**KIRKLEES METROPOLITAN COUNCIL
INVESTMENT & REGENERATION SERVICE**

DELEGATED DECISION TO DETERMINE PLANNING APPLICATIONS

Reference No:	2025/62/90048/W
Site Address:	82, Cow Heys, Dalton, Huddersfield, HD5 9RG
Description:	Erection of single storey side extension and front and rear ramps
Recommending Officer:	Joshua Merriman

HOUSEHOLDER DELEGATED REPORT

client	KIRKLEES MC		
project	EXTENSION AND ADAPTATIONS 82 COW HEYS DALTON, HUDDERSFIELD HD5 9RG		
drawing	PROPOSED PLAN, ELEVATIONS & SITE PLAN		
revision	notes	date	drawn
scale :	1:50 AT A1	12.24	PB
project no.	2396	drawing no.	02

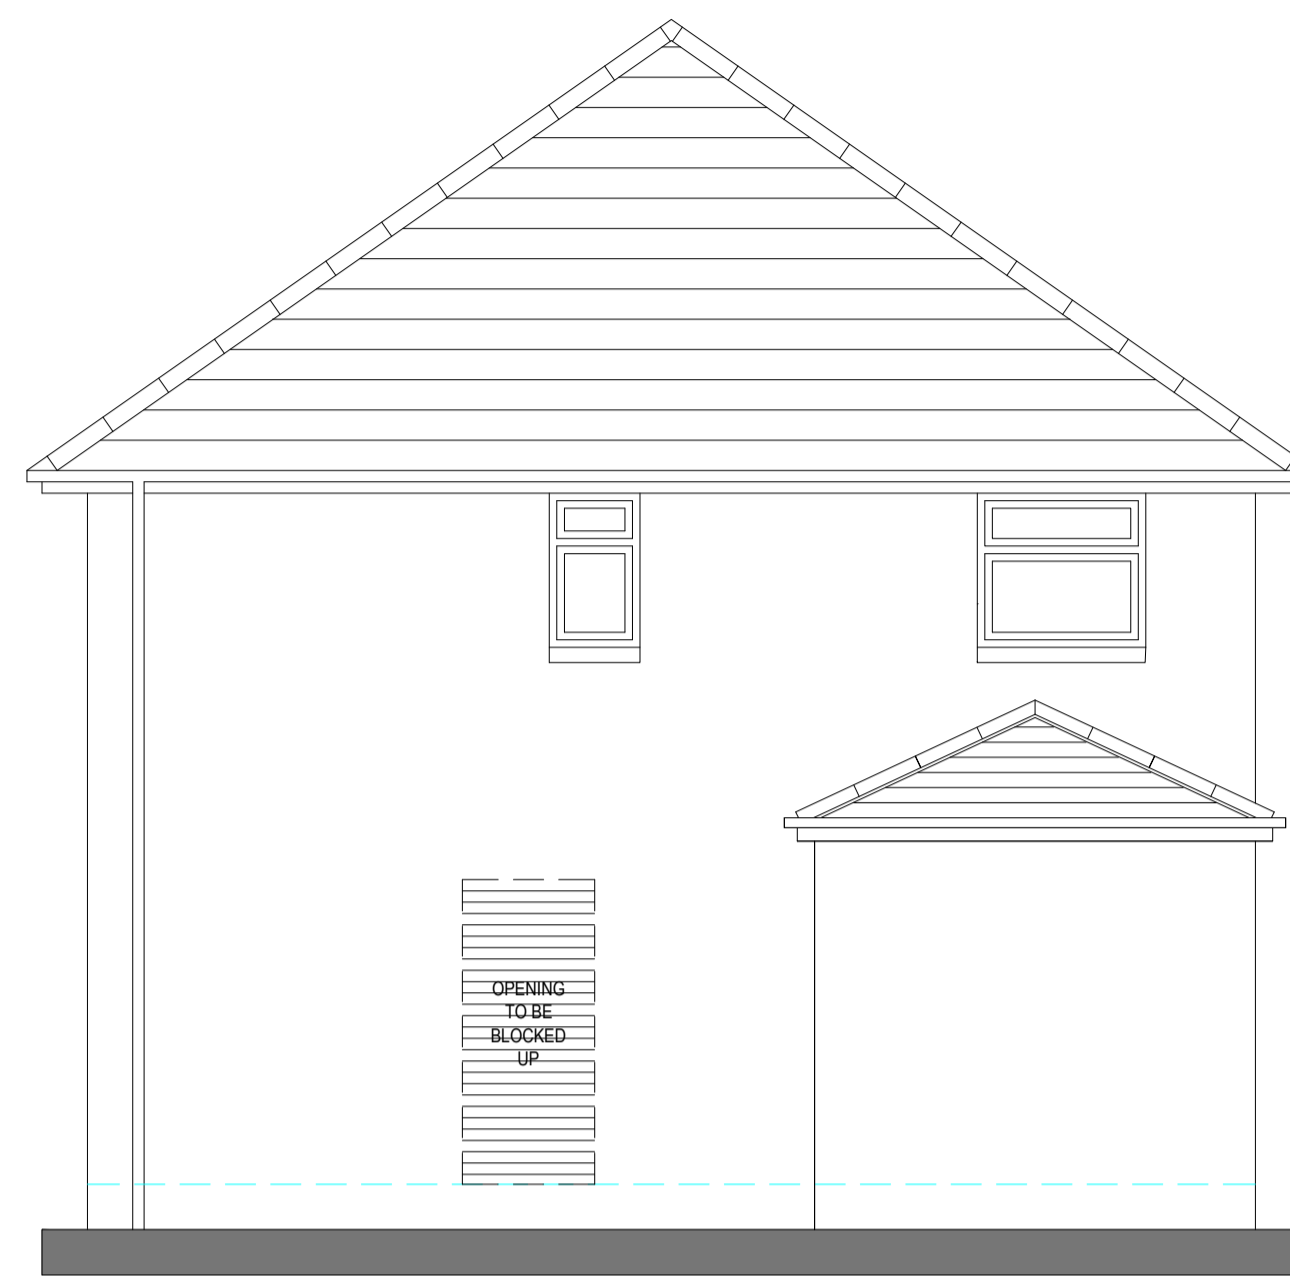
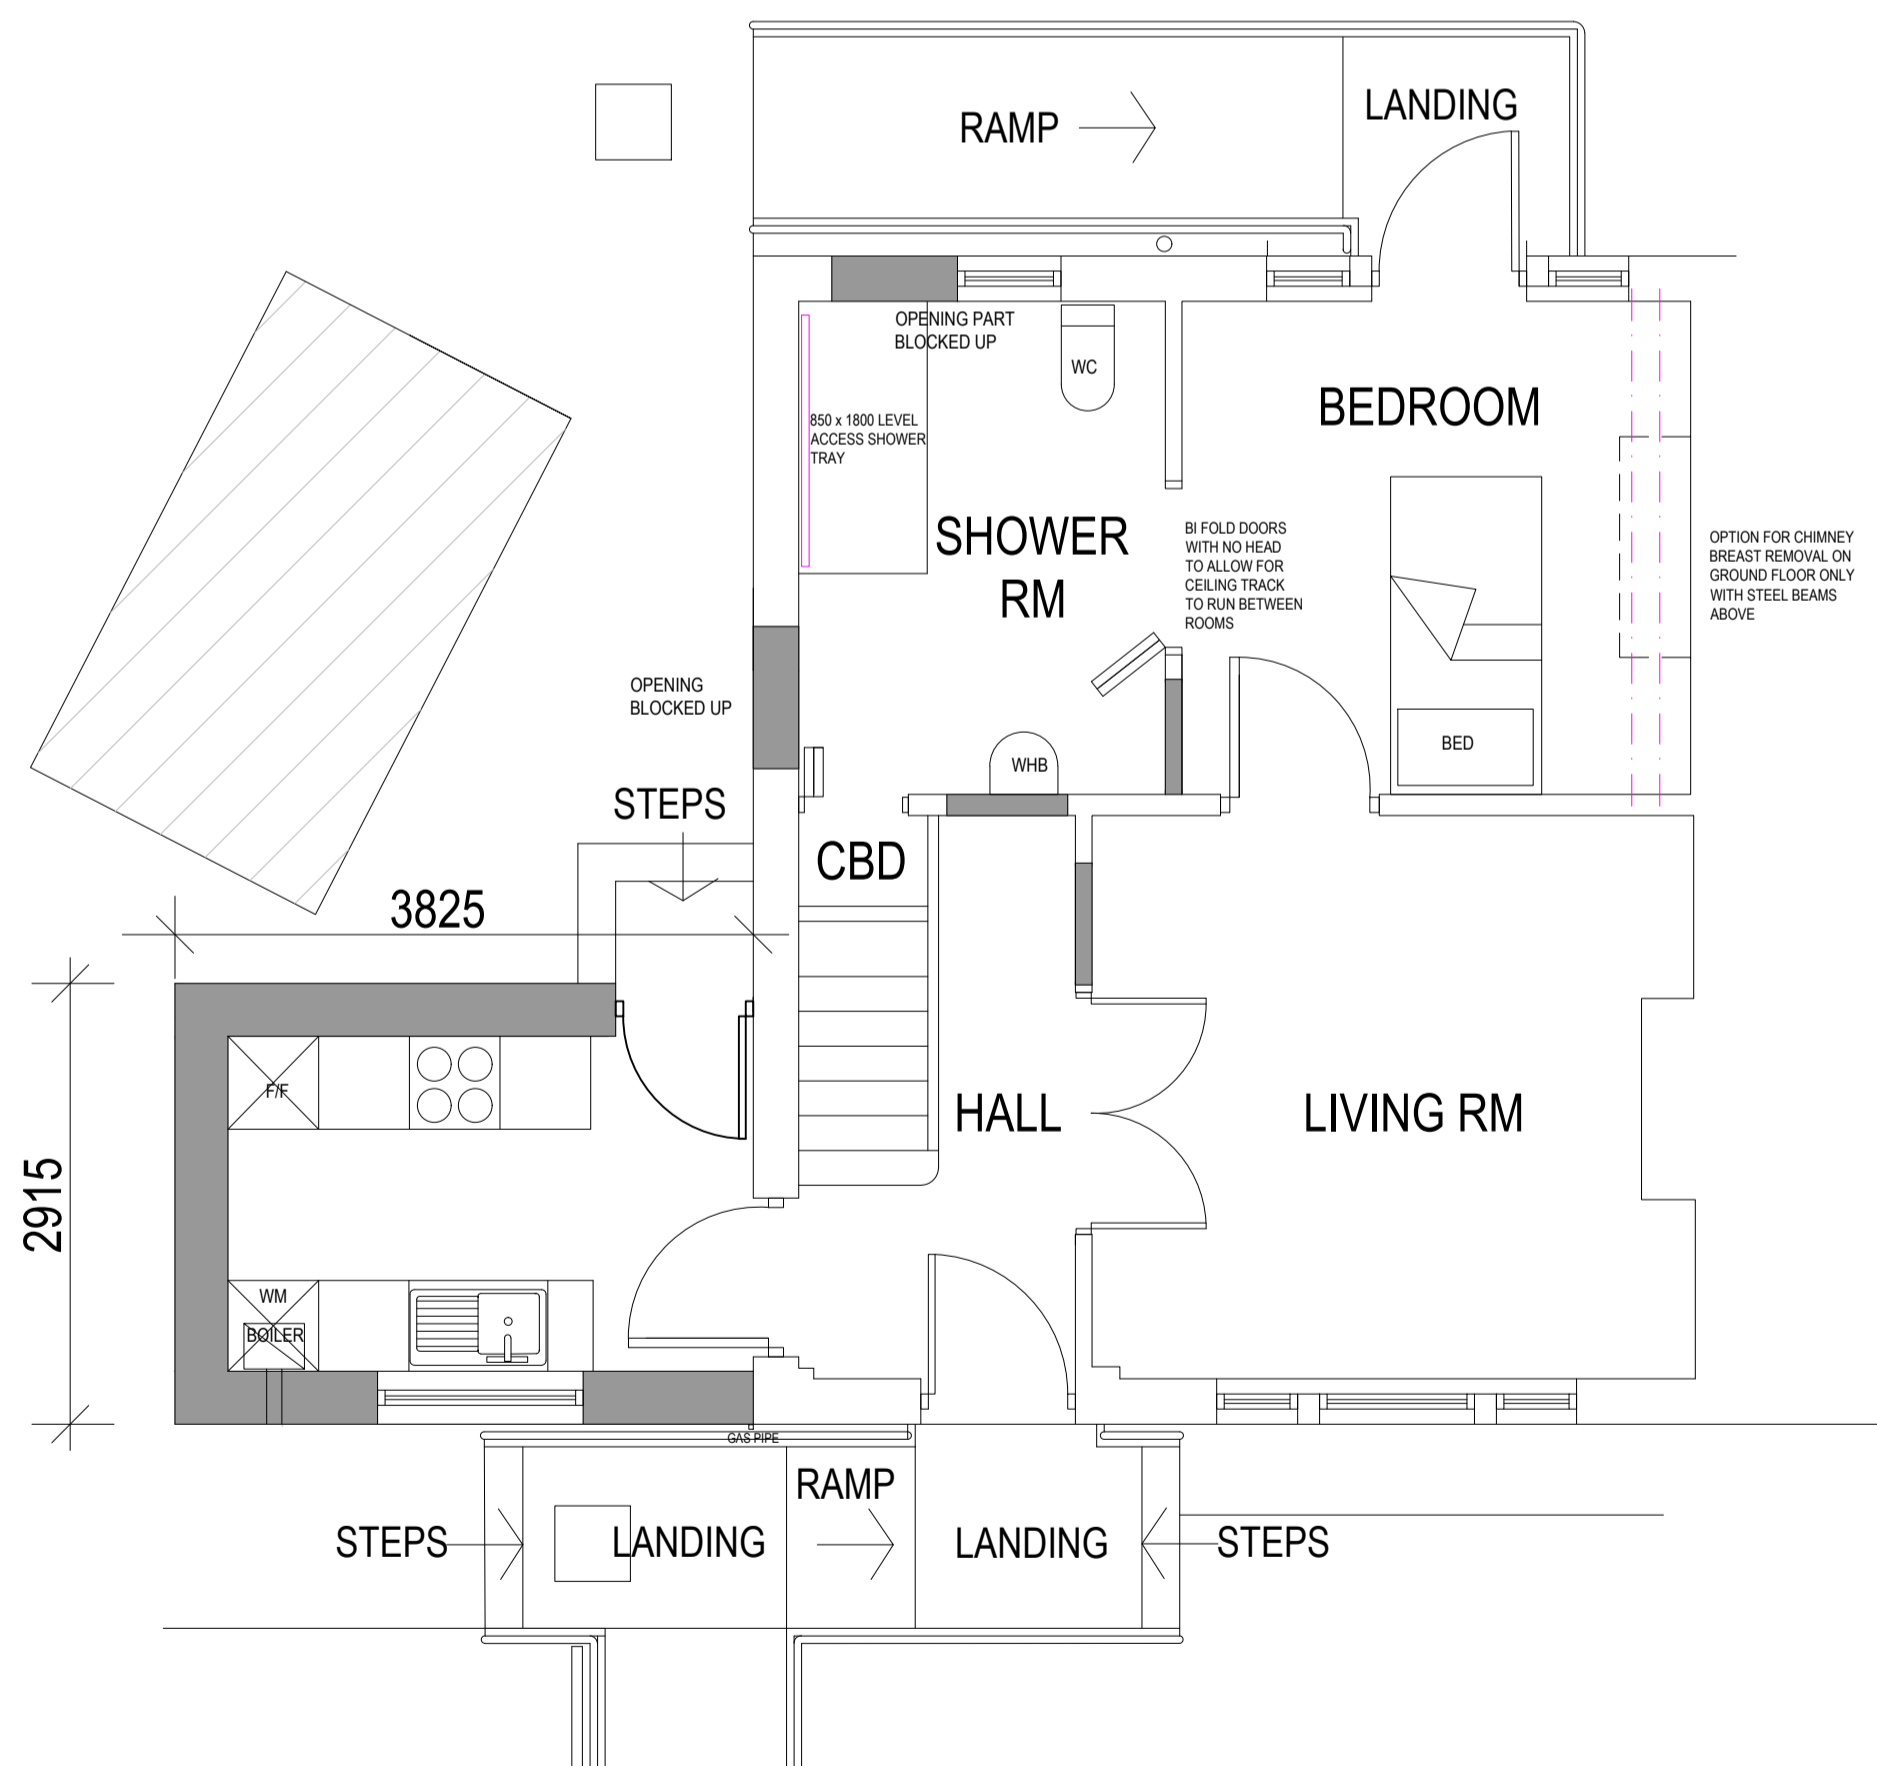
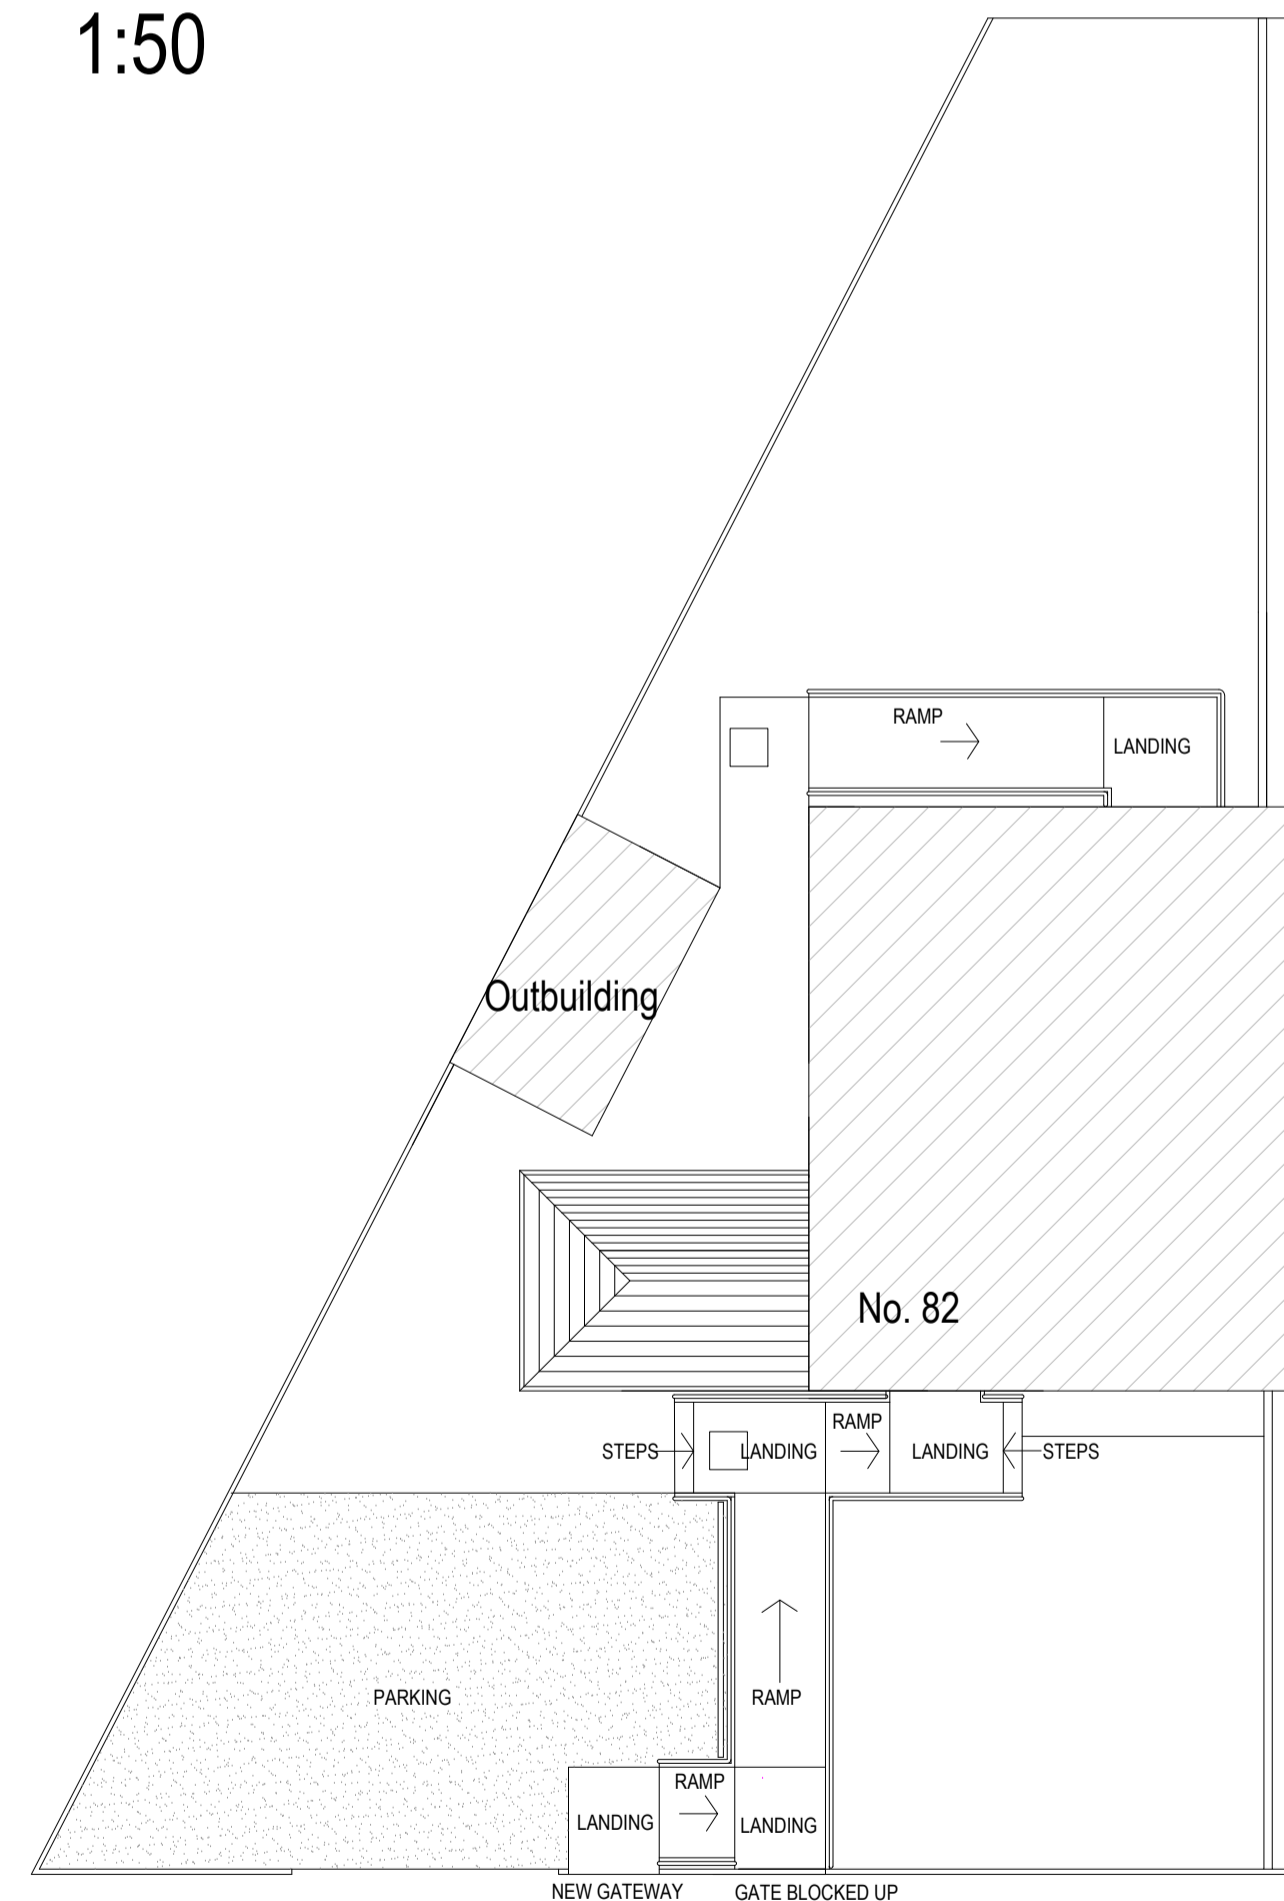
YES / NO	SUMMARY
Negotiations/Amendments during course of application	Yes	The case officer requested confirmation of the material used for the ramps to the front and rear of the dwelling. They will be formed with concrete flags, with a concrete flag upstand, and black tubular steel handrails as a standard accessible homes' specification.
Parish/Town Council comments sought	No	
Planning History	No	
Consultations required	No

The proposed side extension would project 3.82m from the side elevation of the existing building, with a maximum height of 3.5m, eaves height of 2.56m, and a depth of 2.91m.

Side extensions	<u>Yes - COMPLY</u>	<u>No - JUSTIFY</u>
Ensure reasonable levels of natural light to the habitable rooms in neighbouring properties	Due to the limited scale of the extension, it is considered that there will be no significant impact on light to habitable rooms in neighbouring properties.	
Positioning windows to minimise or avoid any potential overlook into neighbouring gardens	There will be no new windows in the side elevation. There would be a new glazed door to the rear of the proposed extension, however this would present similar views to the existing. Therefore, it is considered that no overlooking will be facilitated into neighbouring gardens.	
Single storey side extensions should:		
not extend more than two thirds of the width of the original house	The width of the original house is 6.38m, whereas the extension will have a width of 3.82m, which is not more than two thirds of

the width of the original house.	
not exceed a height of 4 metres	The maximum height of the extension will be 3.5m, not exceeding 4m.	
be set back at least 500mm from the original building line to allow for a visual break		While the extension does not include the standard 500mm setback, a clear visual break is maintained due to the physical gap between the proposal and the neighbouring dwelling to the northeast, preventing a terracing effect. As the extension will be single storey, it remains subservient to the host dwelling and does not compromise its architectural integrity. Additionally, the differing orientation of the dwelling further reduces visual impact on the street scene. Given these factors, the absence of a setback is not considered to result in harm, and the proposal is acceptable in this instance.

<ul style="list-style-type: none"> • Policy LP24 Design (a), (c) and (d) of the KLP • Chapter 12 of the NPPF 	original building in terms of height, scale, and massing as it would be of a single storey, have a modest footprint incorporate a hipped roof as to reduce bulk.	
Facing materials and detailing	<ul style="list-style-type: none"> • KDP 9 of the SPD • Policy LP24 Design (d) (iii) of the KLP • Chapter 12 of the NPPF 	The extension will be faced in brick, with white uPVC windows, and uPVC doors, all to match the host dwelling. The proposed ramps will be constructed from concrete flags, and a concrete flag upstand to match the hard-standing area to the front of the dwelling, and black tubular steel handrails which are standard accessible homes spec and therefore considered acceptable.	✓
Roof style	<ul style="list-style-type: none"> • KDP 1 and 2 of the SPD • Policy LP24 Design (a), (c) and (d) of the KLP • Chapter 12 of the NPPF 	The extension will have a hipped roof indicative of the host dwelling and use a red concrete tiled roof to match that of the existing house.	✓

Window proportions	<ul style="list-style-type: none"> • KDP 1 and 2 of the SPD • Policy LP24 Design (a), (c) and (d) of the KLP • Chapter 12 of the NPPF 	The windows proposed in the front of the extension are proportionate to those existing in the house in terms of size and positioning.	✓

Accessibility for all users	<ul style="list-style-type: none"> • KDP 17 of the SPD • Policy LP24 Design (f) • Chapter 12 of the NPPF 	Ramps are proposed to the front and rear of the dwelling, making it accessible for all users.	✓
-----------------------------	---	---	---
